**KIRKLEES METROPOLITAN COUNCIL
INVESTMENT & REGENERATION SERVICE**

Reference No:	2025/70/90241/W
Site Address:	14, Firth Street, Huddersfield, HD1 3BA
Description:	Variation of condition 2 (plans) on previous permission 2023/93782 for erection of extensions and alterations to form 16 student apartments
Recommending Officer:	Farzana Tabasum

DECISION – Section 73 Variation of Condition – Approve

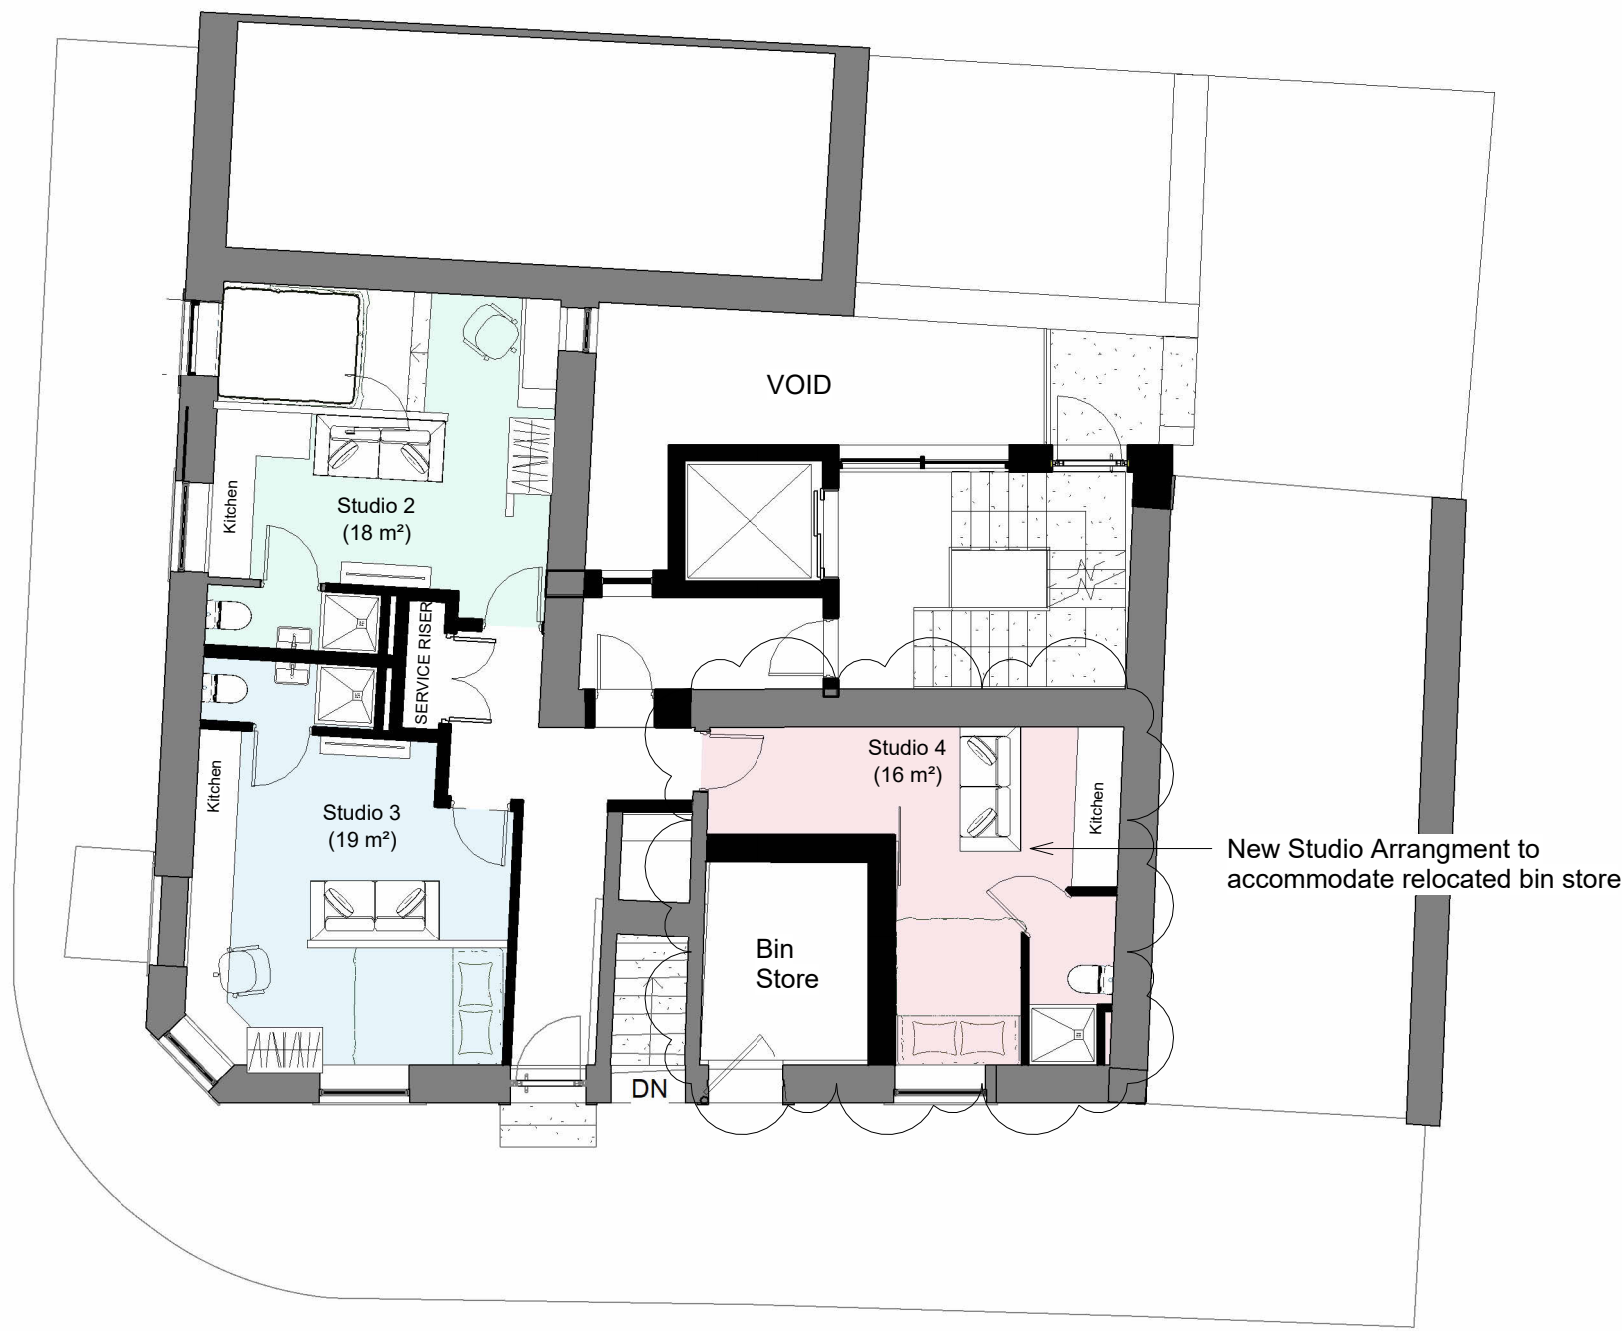
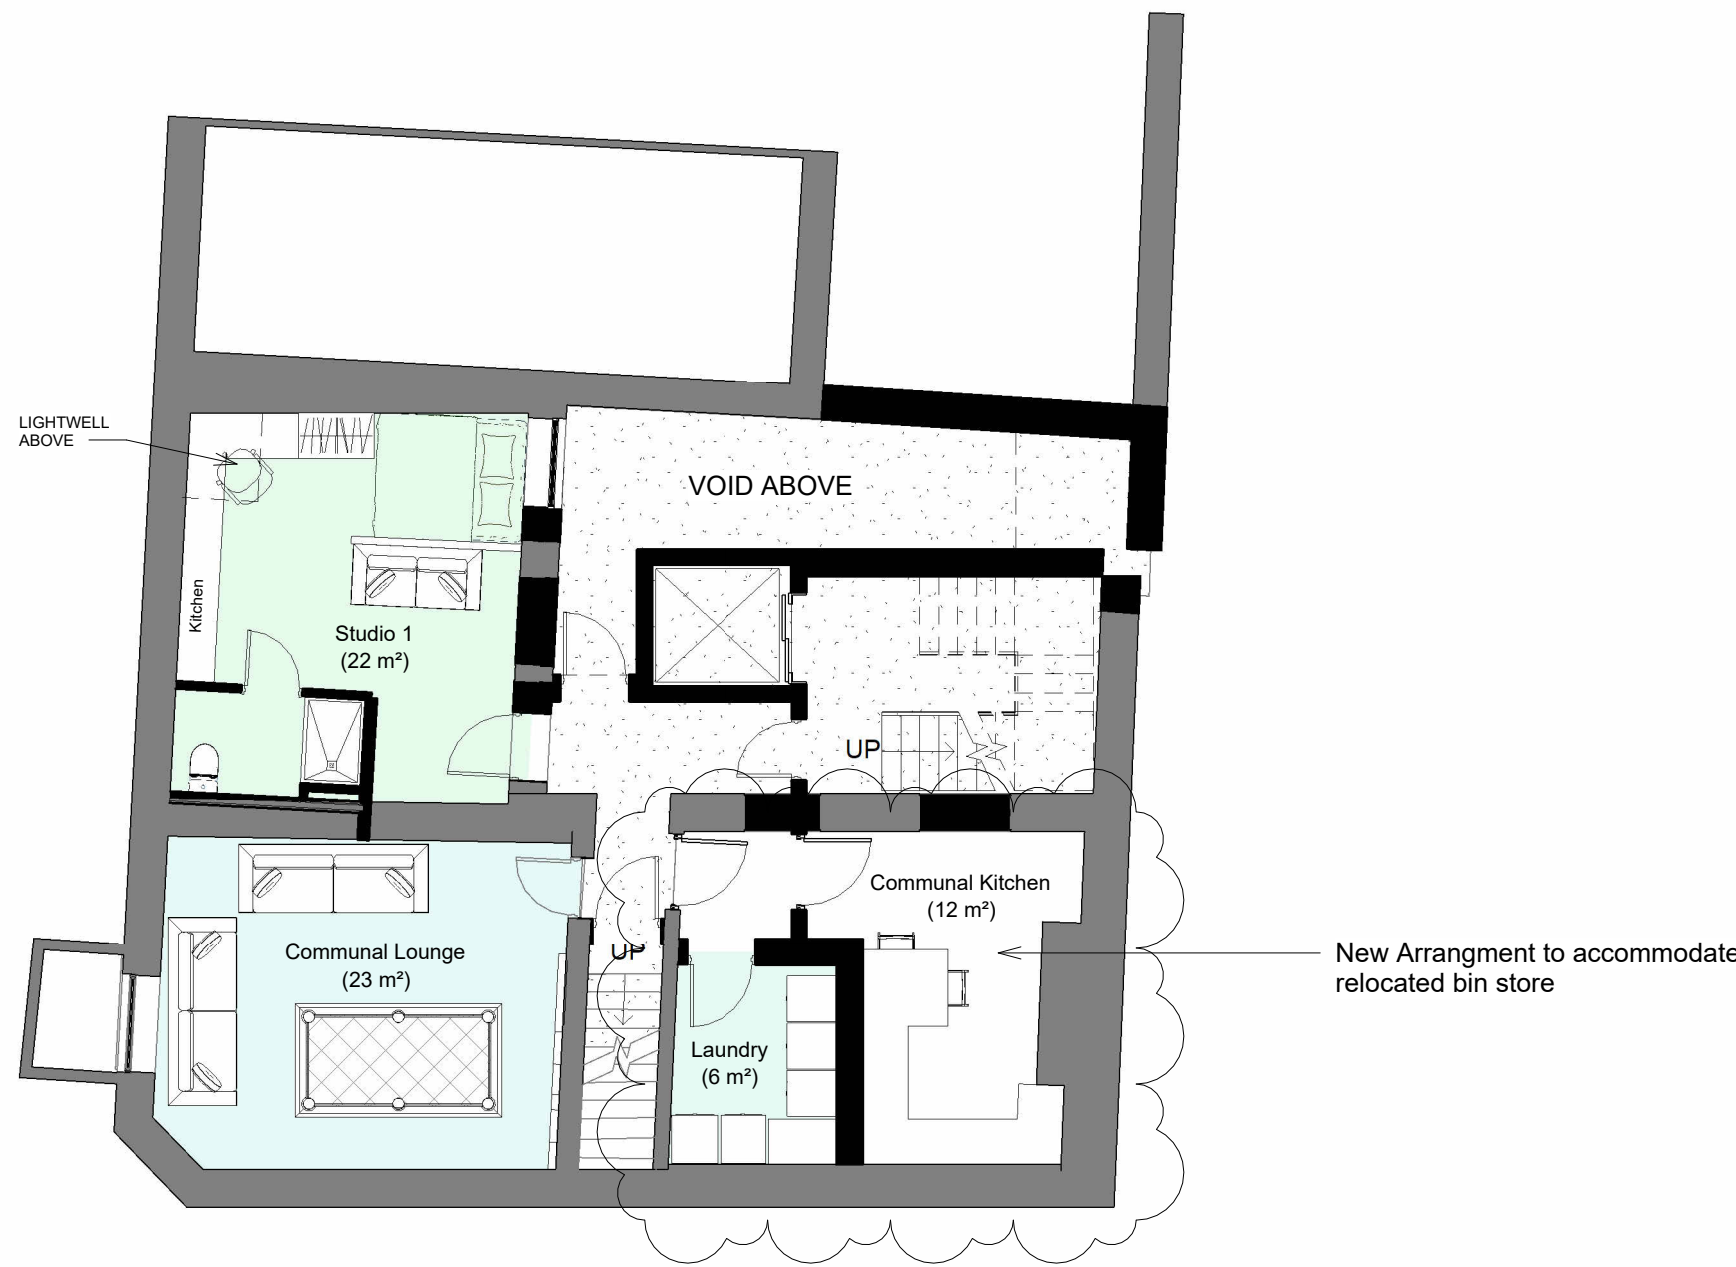
The variations proposed primarily relate to providing an internal bin storage area, adjacent to studio 4 on the ground floor, with direct access onto Firth Street.

As a result of the proposed variations, the floor space within the communal areas on lower ground and the three apartments on the ground floor would be reduced. The most notable change would be to studio apartment no. 4, the floor space of which would be reduced from 26sqm as approved, to providing 16sqm. The applicant also advises that amendments to the lower ground floor/basement, will ensure the load bearing walls are aligned. Consequently, the variation to provide an internal bin storage area will result in a minor amendment to the front elevation on the ground floor to replace a door with a locked gate to the proposed bin storage area. Residents of the apartments are stated would have a key or access code to allow access to the bin storage area.

Requested amended plans to address concerns raised by Waste strategy officers, to include drainage channel, bin dimensions, omit graphical errors on plans and show gate opening inwards into bin store. The final amended drawings were received on 04/07/2025.

K.C Environmental Health – To ensure the shared wall with studio 4 and bin store be constructed adequately and sealed to prevent any sound and odour penetration to the adjoining apartments. Whilst an addendum can be provided to the previously approved noise report, this is not necessary. Informal discussions

Environmental Health officers have advised that the onus is on the applicant to ensure the shared wall with studio 4 and bin store be constructed adequately and sealed to prevent any sound and odour penetration to this apartment, to avoid any concerns from the future occupants of this apartment.

- works which form part of the sound attenuation scheme, specifically 'Alternative 2', of the Acoustic Report (dated: 05 December 2023) shall be completed,
- the construction of any party wall and ceilings, adjoining the bin storage area and that of any adjoining apartment shall be constructed to prevent noise and odour penetration from the bin storage area, and
